**EL PASO COUNTY PLANNING AND
 COMMUNITY DEVELOPMENT
 DEPARTMENT**

GRADING AND EROSION CONTROL PLAN CHECKLIST

GRADING & EROSION CONTROL PLAN

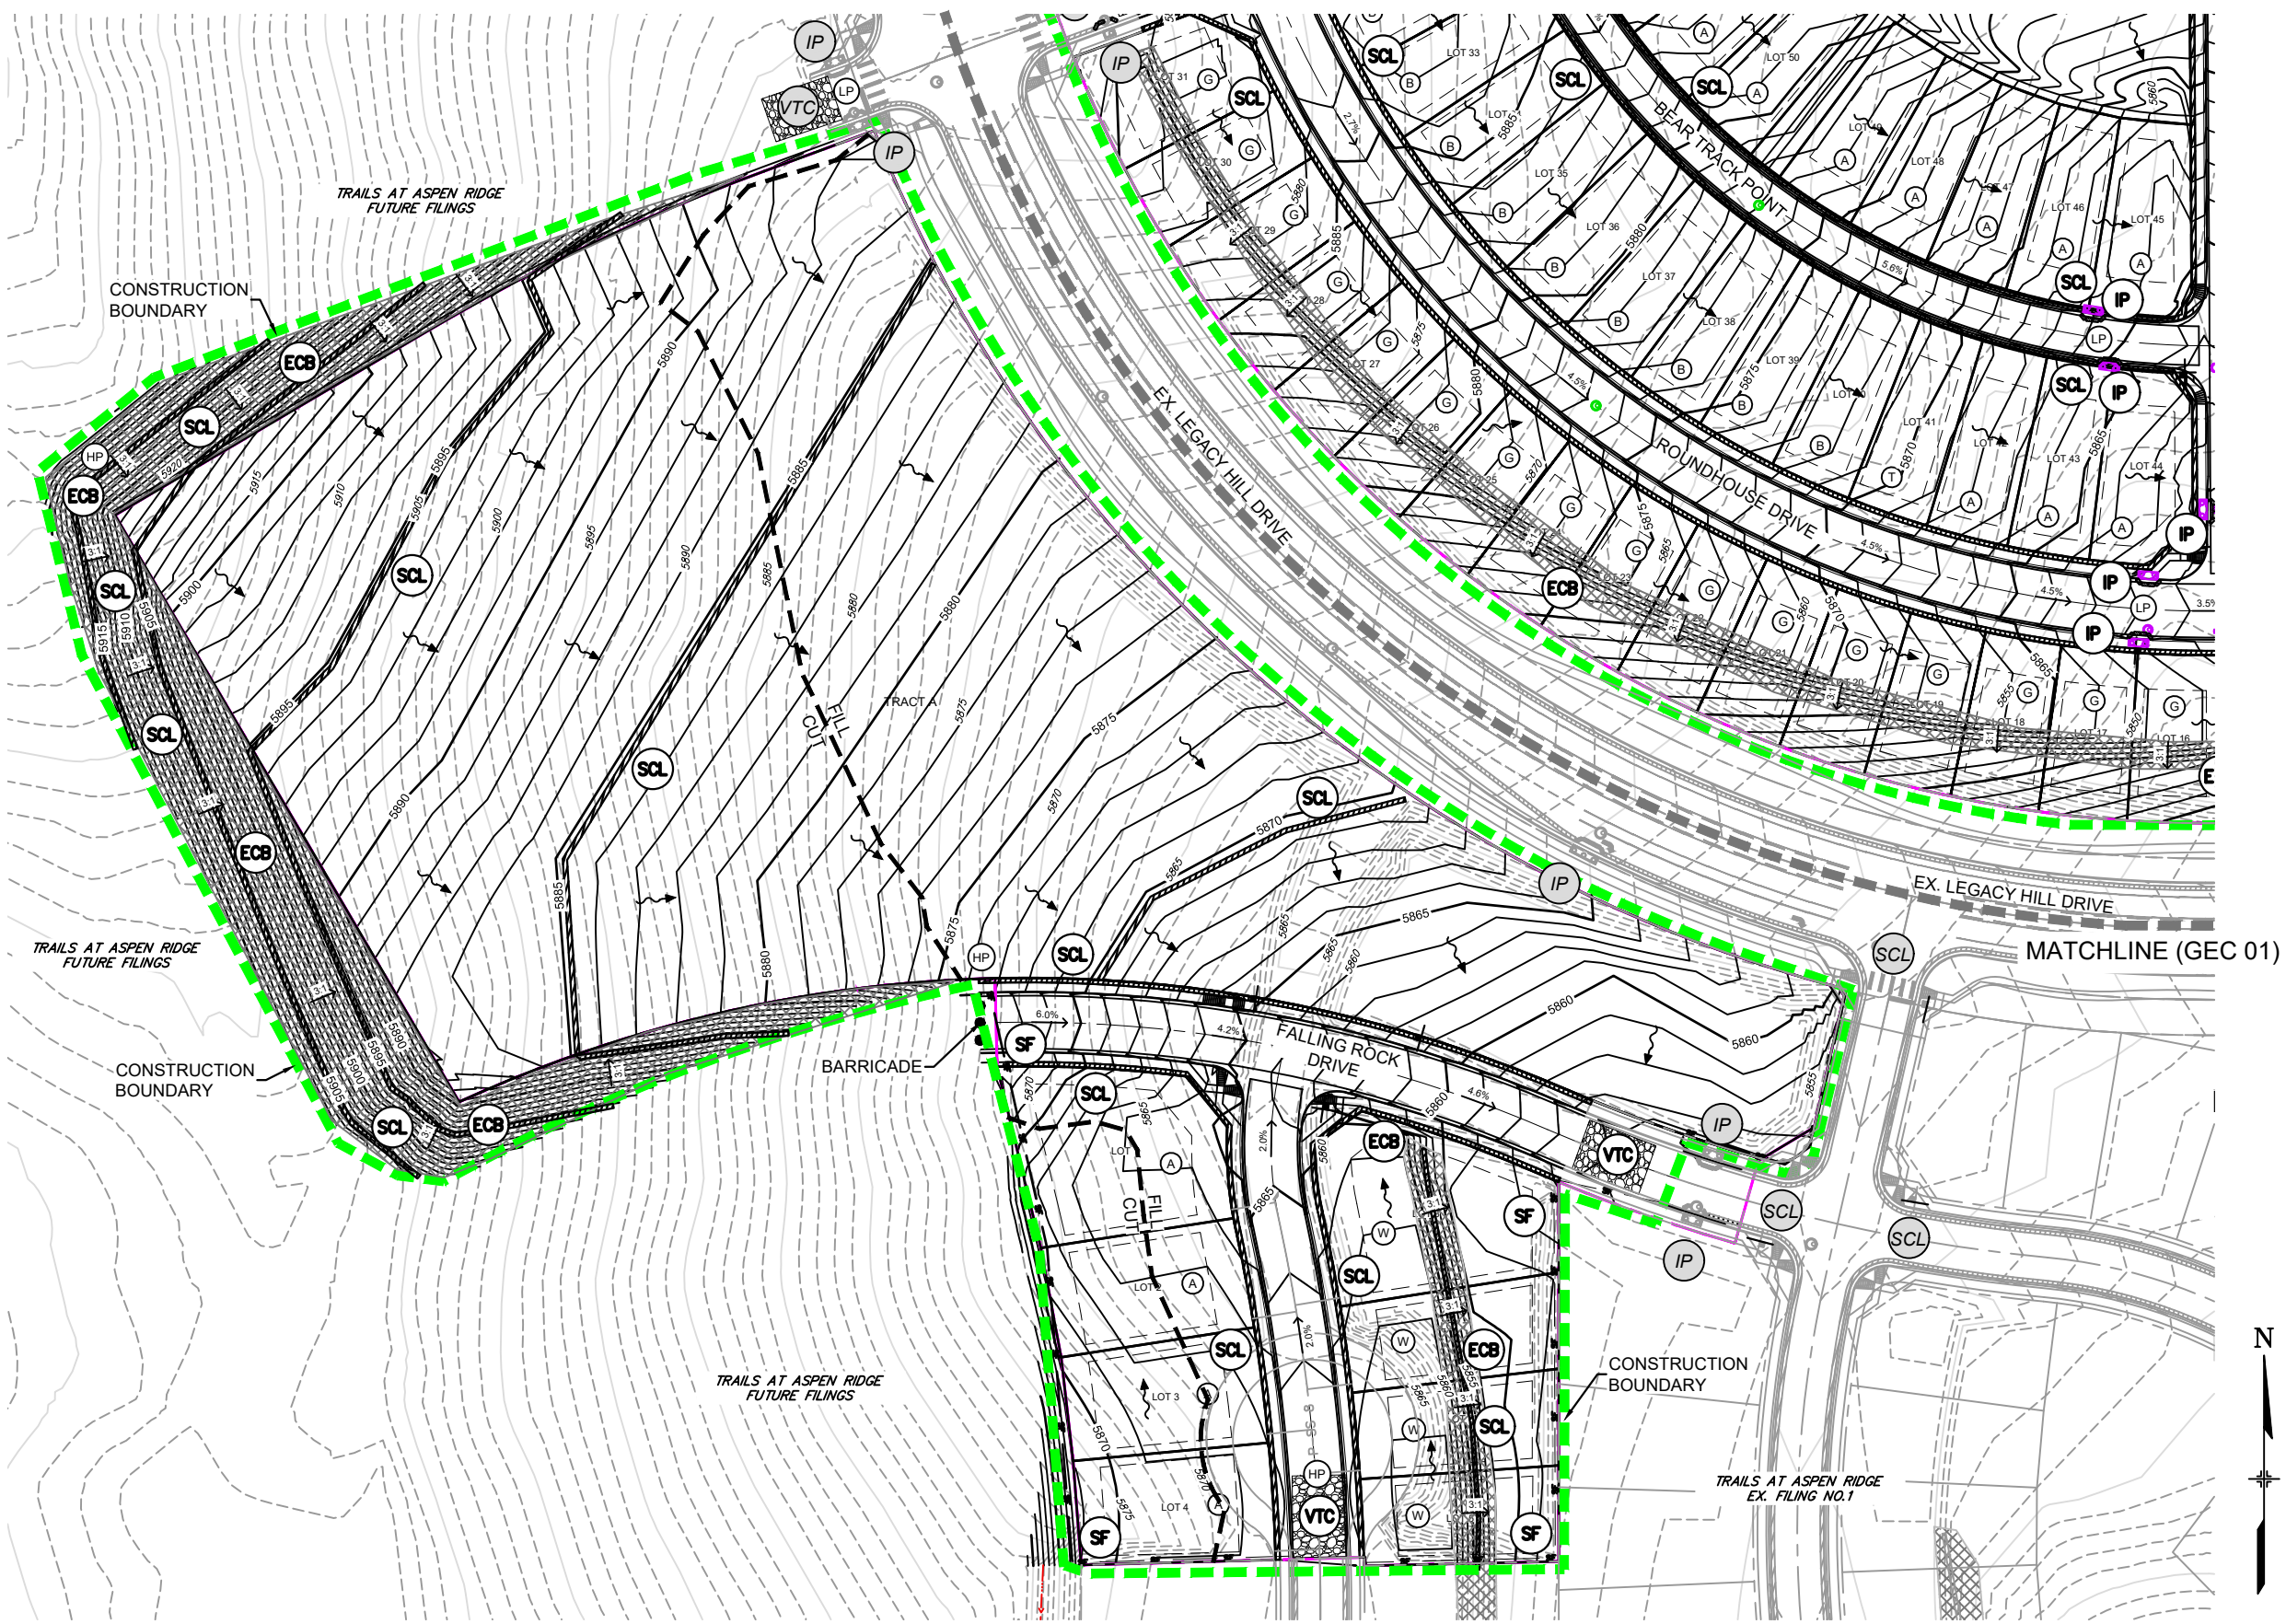
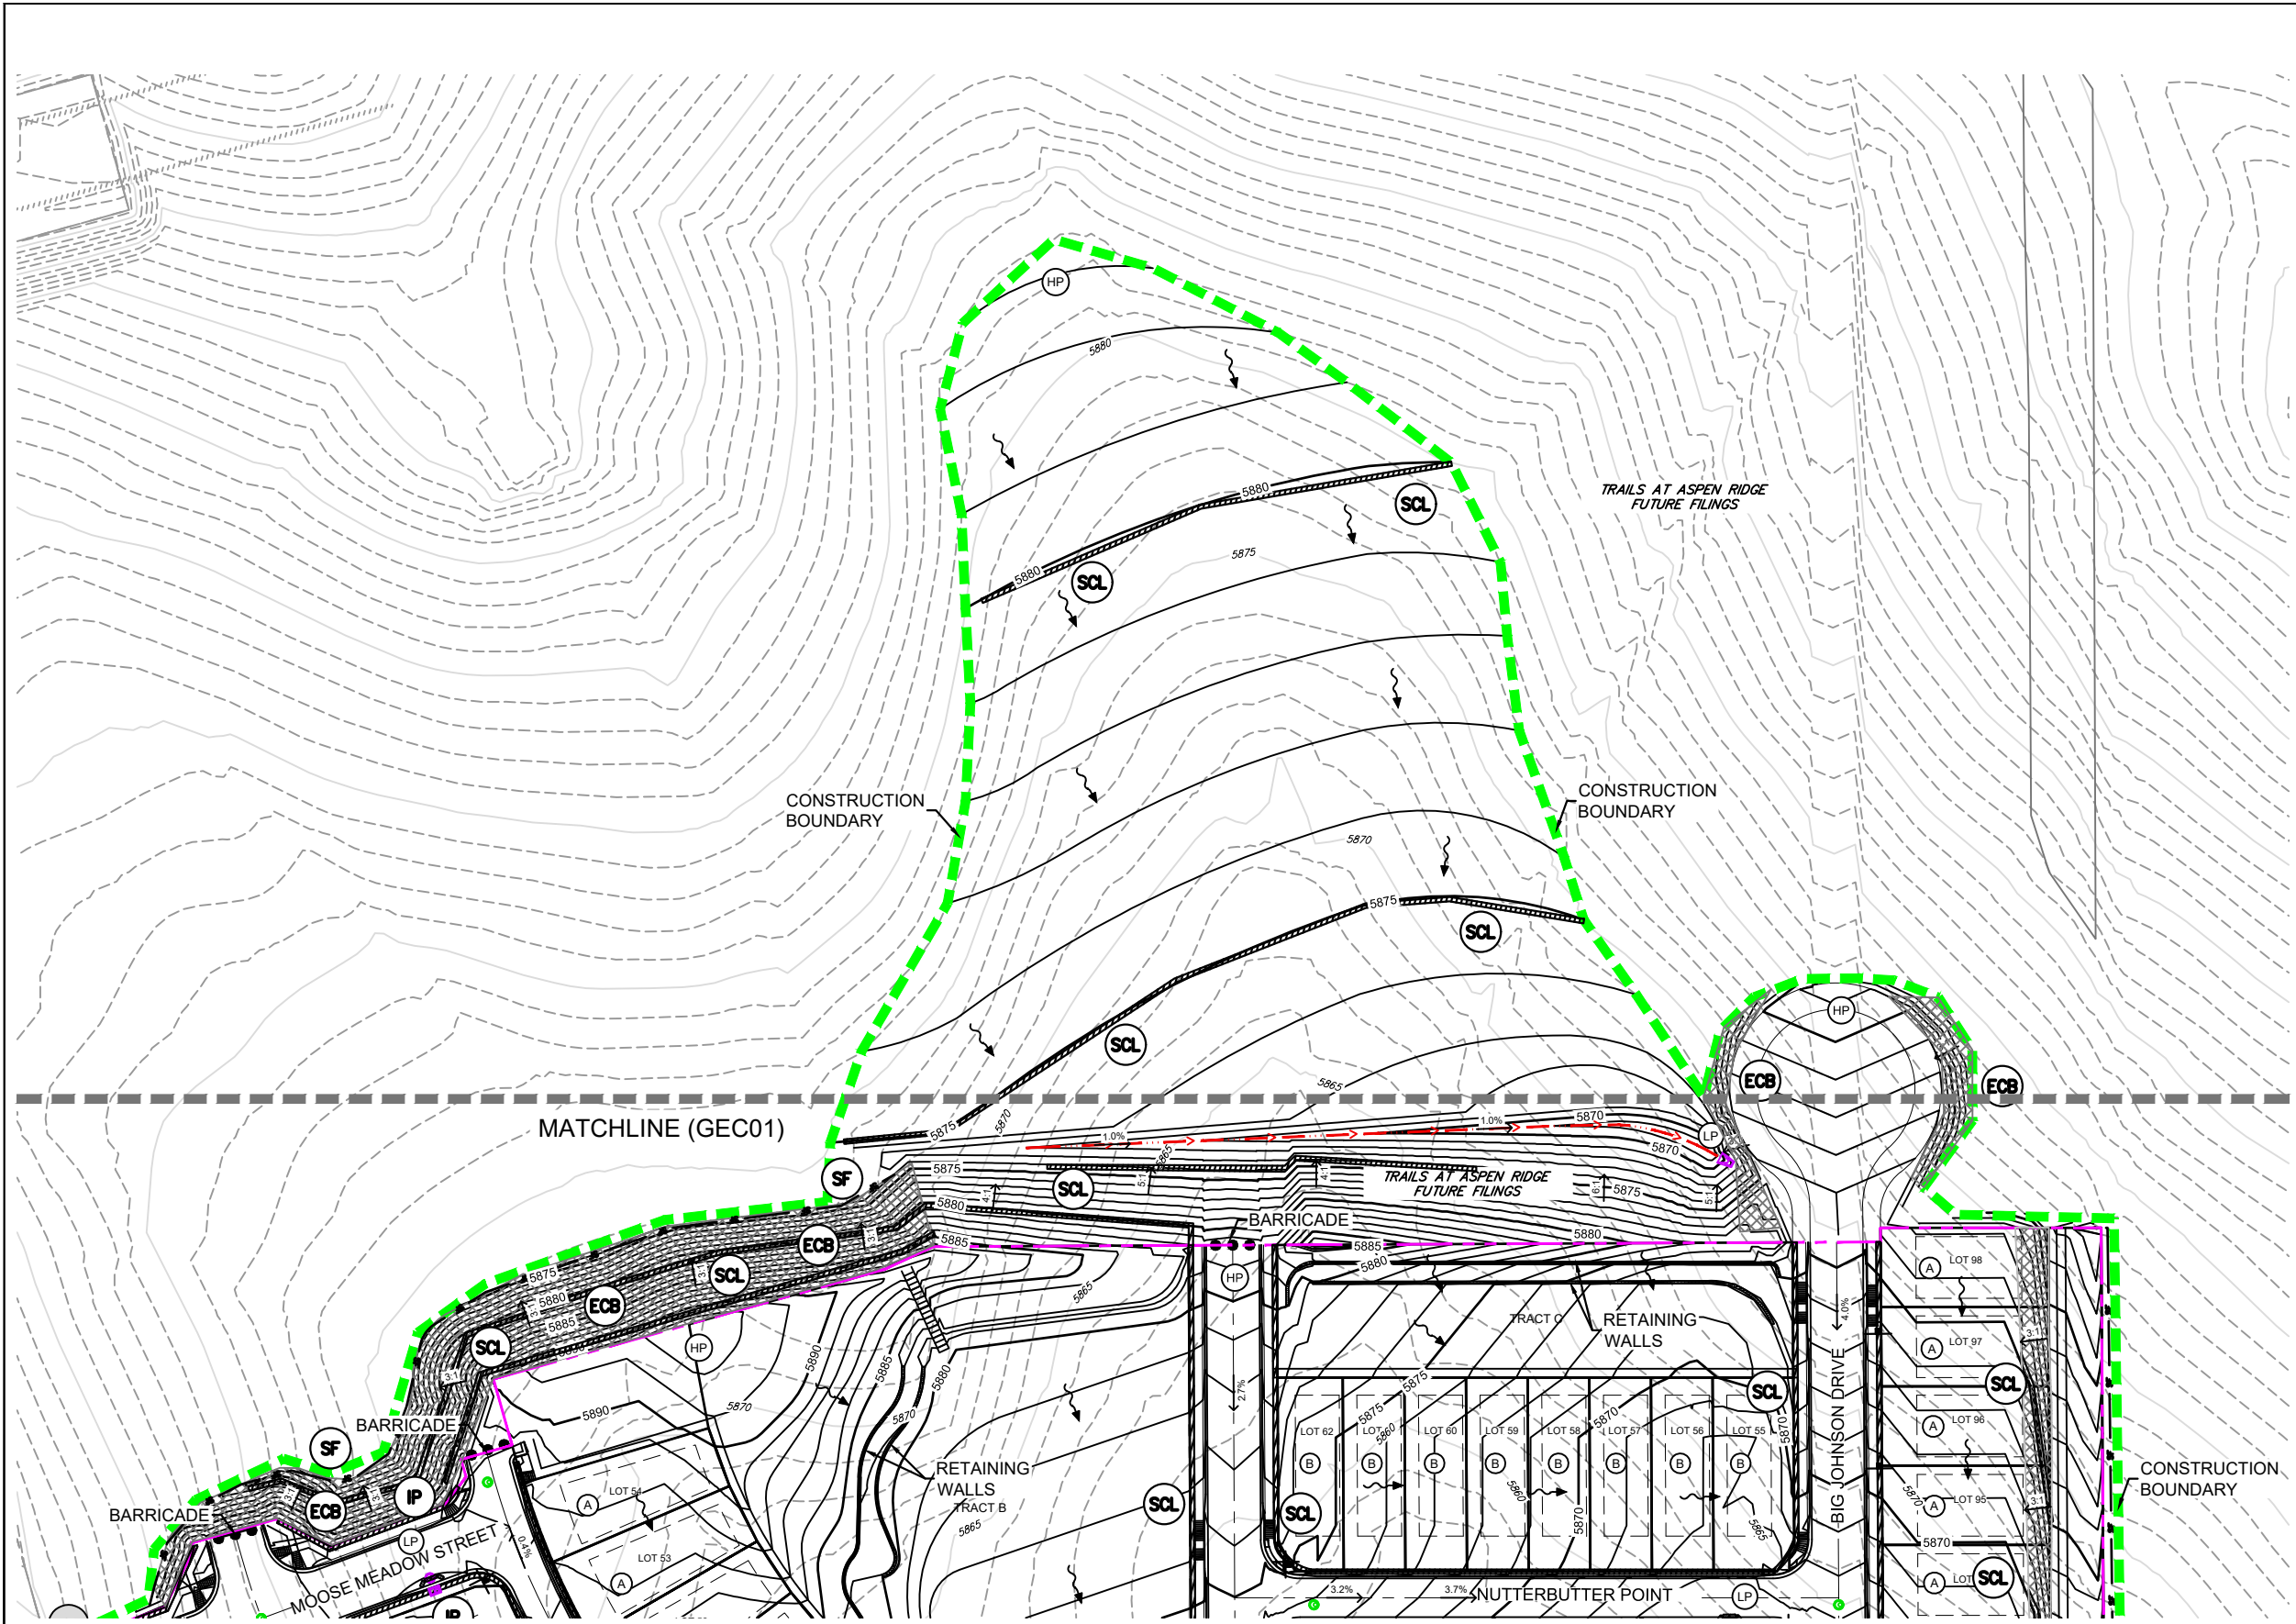
Please address. A note indicating the existing vegetation may be added to the plans.

see comments on the GEC plan

The notes provided on the GEC plan do not match the notes in the check list. Please revise the notes on the plan so that they match these notes.
